**WELWYN HATFIELD BOROUGH COUNCIL
DIRECTORATE OF STRATEGY AND DEVELOPMENT**

DELEGATED APPLICATION

Application No: 6/2015/2173/FULL
Location: 37 Lambs Close, Cuffley, Potters Bar, EN6 4HD
Proposal: Erection of 2no two bedroom flats together with associated parking and retention of existing car parking spaces following demolition of existing garages
Officer: Mrs J Pagdin

6/2015/2173/FULL

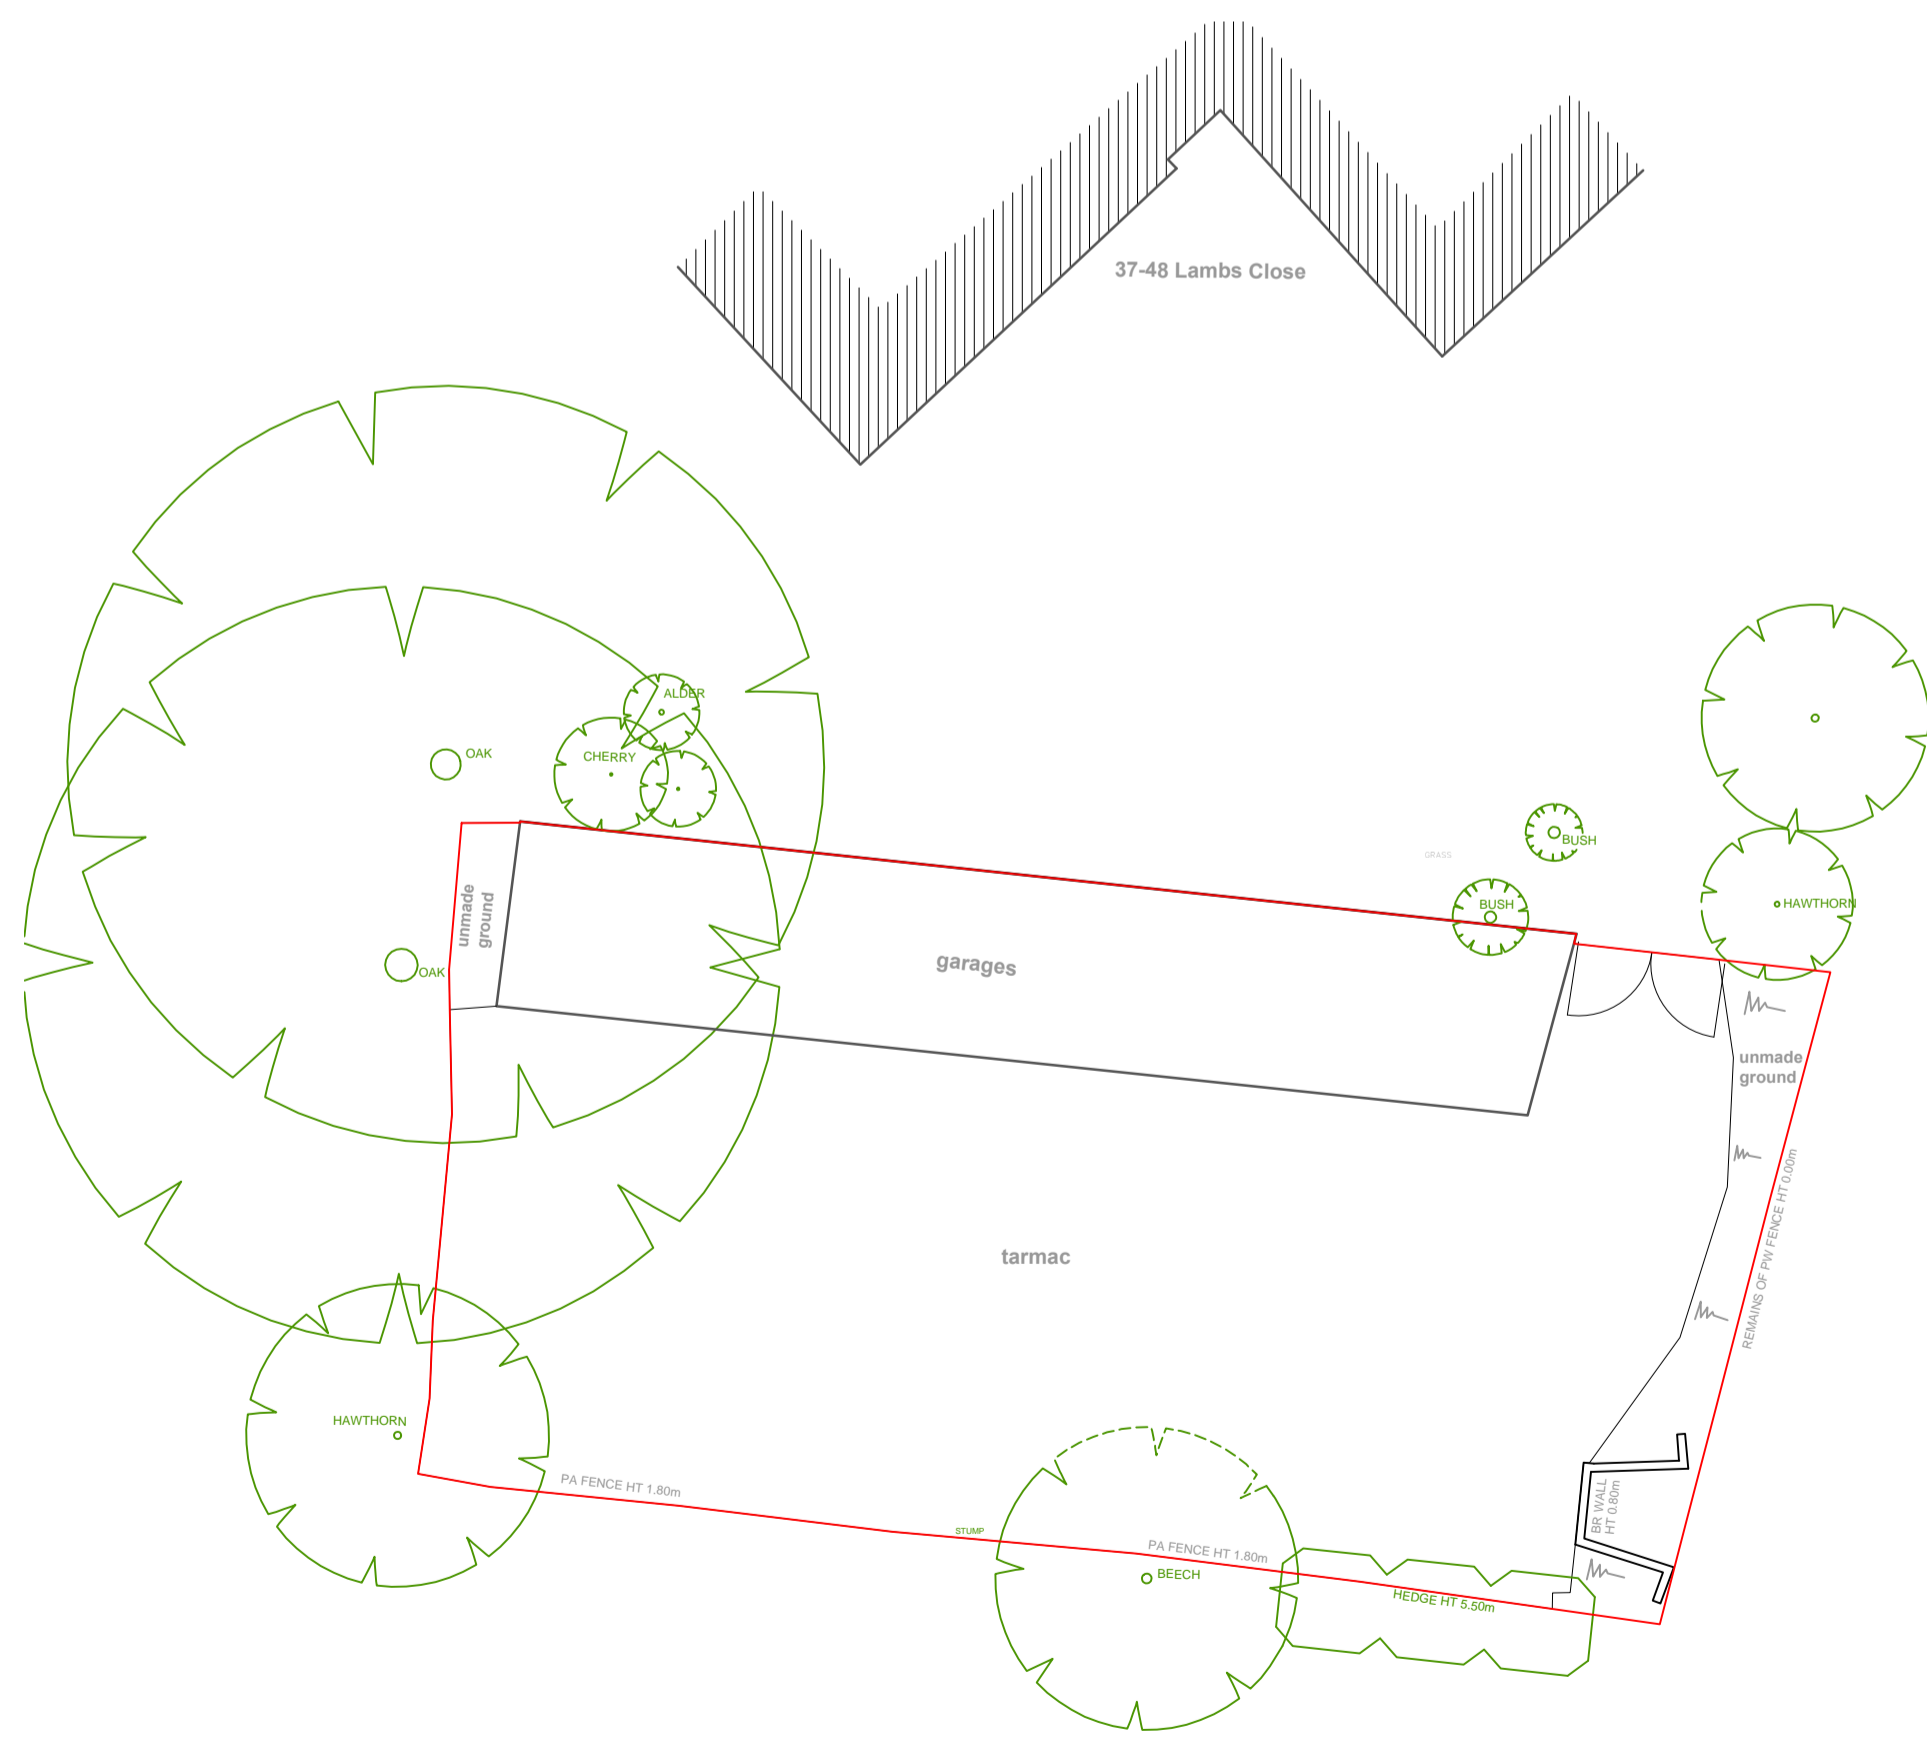
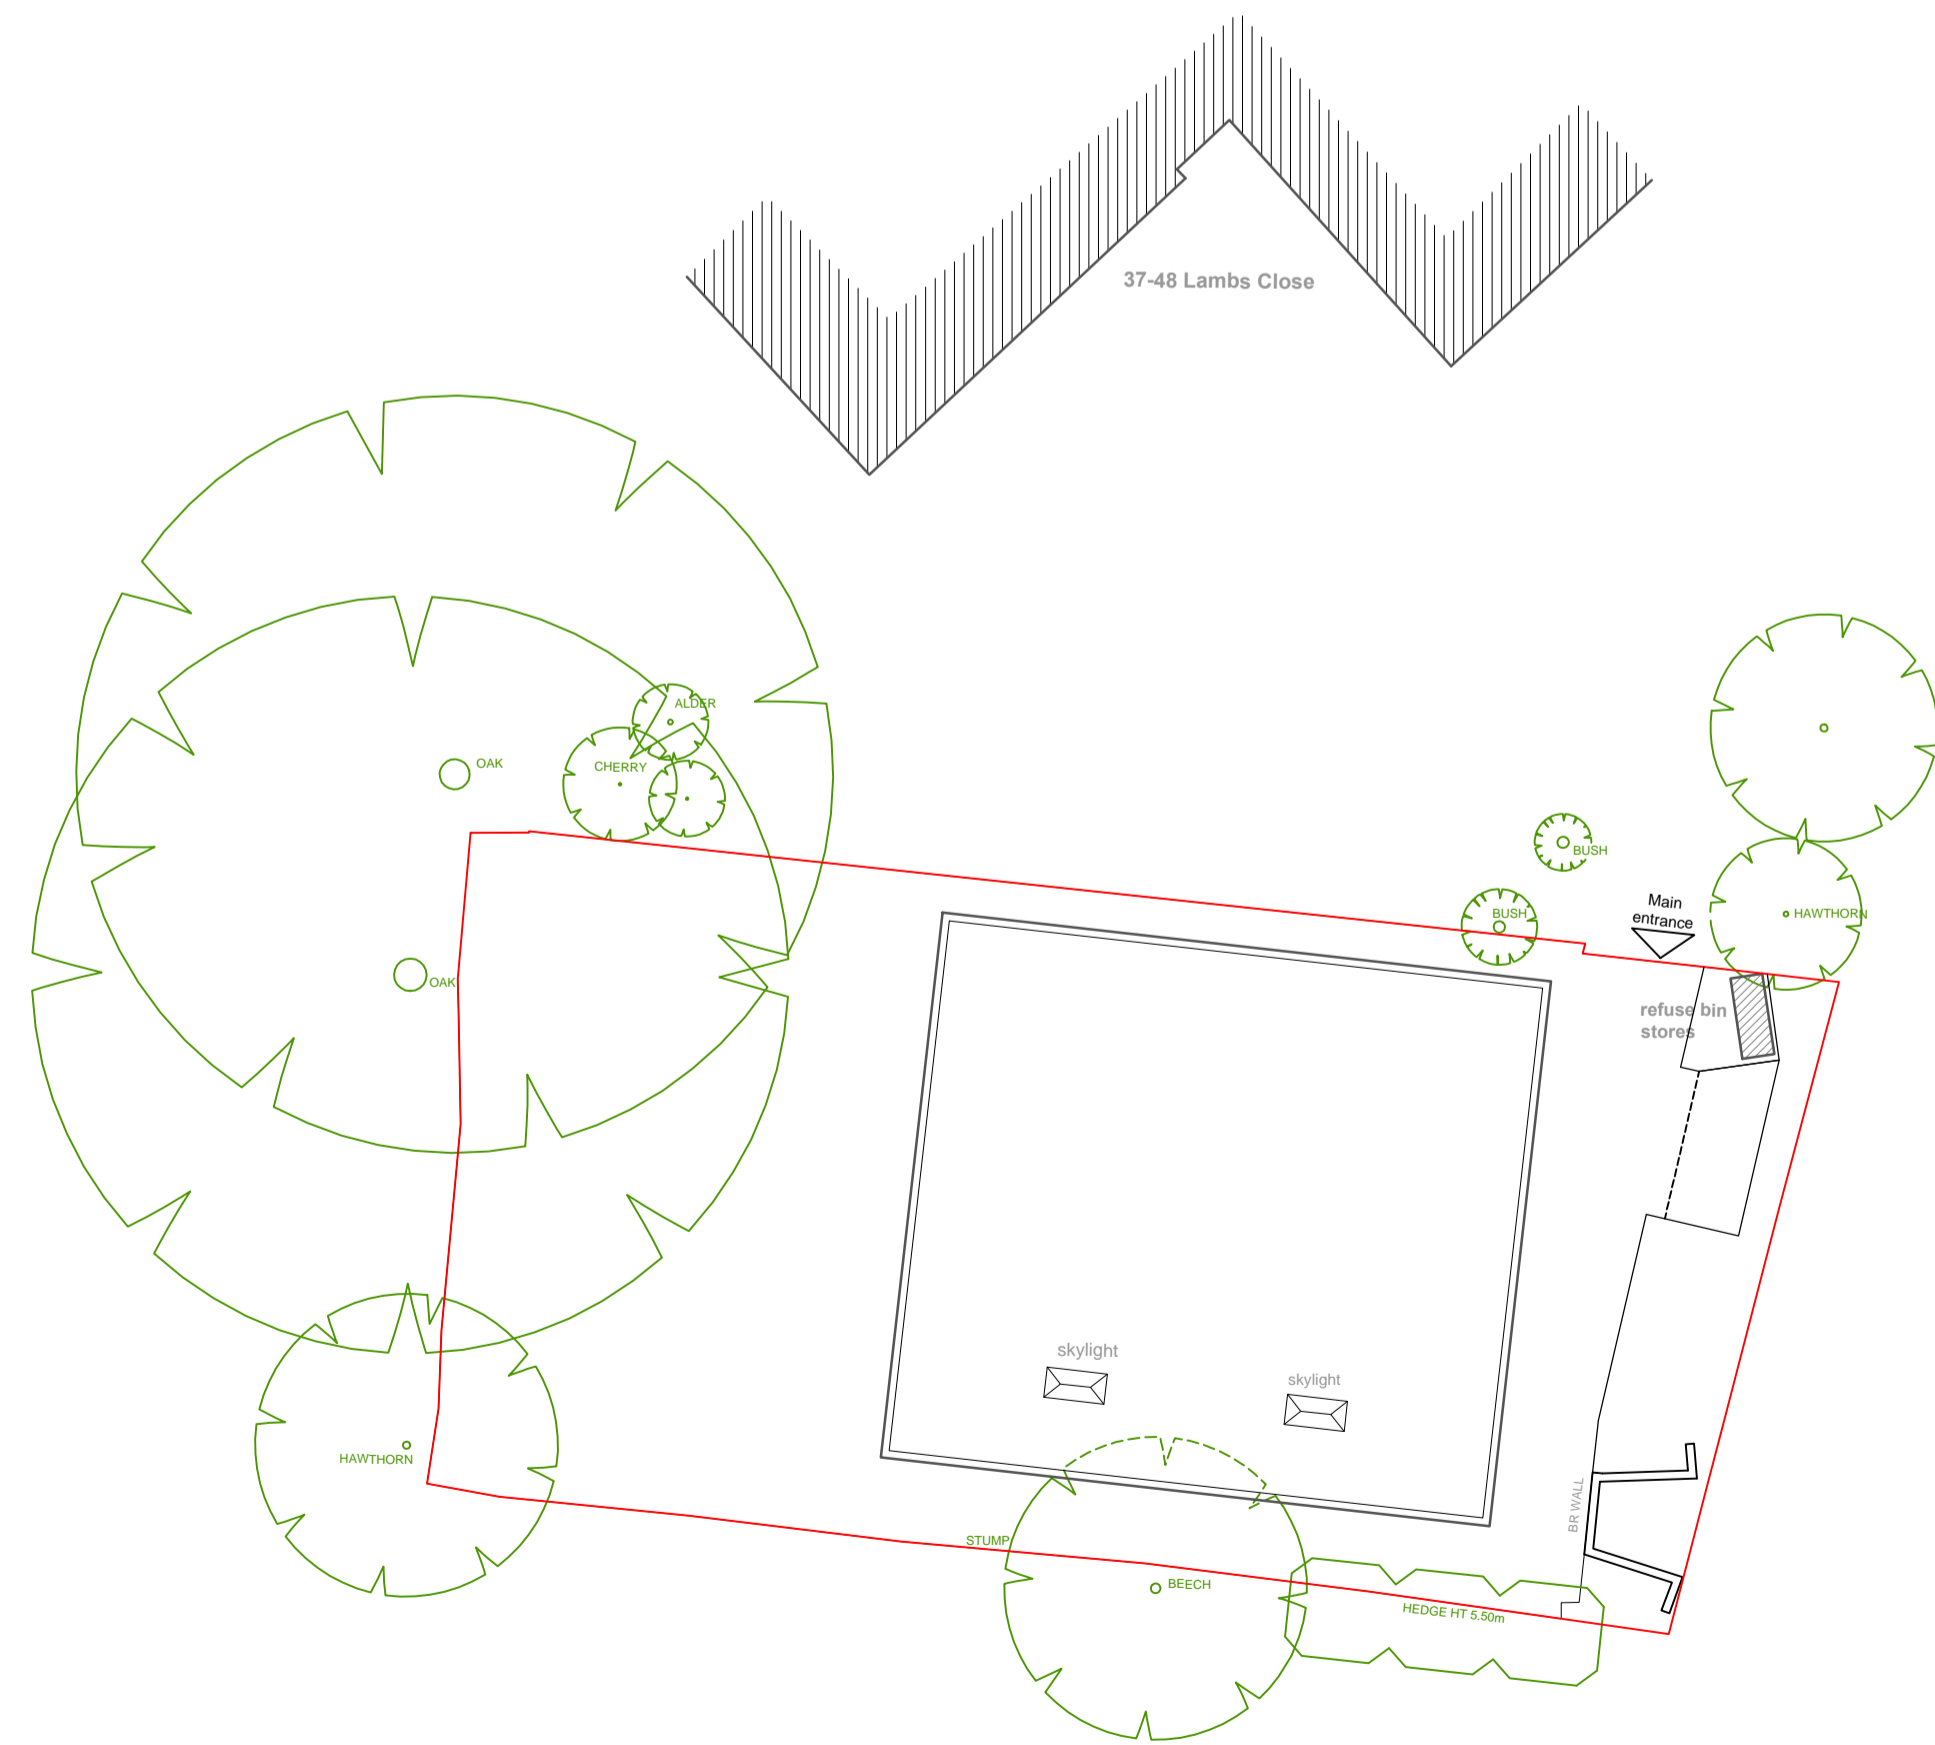
The submitted scheme shows removal of the garages and provision of open parking spaces together with retention of 24 car parking spaces provided on the site.

The scheme also introduces two residential units above the ground level parking spaces. These residential units would themselves generate a demand for additional car parking. The required car parking provision (Supplementary Planning Guidance Parking 2004) for a two bedroom flat is 1.5 parking spaces. The proposed development would create 2 x 2-bedroom flats and so give rise to a demand for 3 additional parking spaces. The submitted layout would provide three spaces for the proposed flats in accordance with the adopted standards but this would result in the loss of 3 spaces reserved for existing flats.

3. The area set aside for 24 car parking spaces shall be laid out, surfaced and marked out, in accordance with Drawing No 1139-301/revB, before the buildings hereby permitted are first occupied. Three spaces shall be retained permanently thereafter for the free parking of vehicles for residents/occupiers of the development hereby permitted and 21 spaces shall be permanently retained for residents of Blocks A, B, C and D Lambs Close and shall not be used for any other purpose.
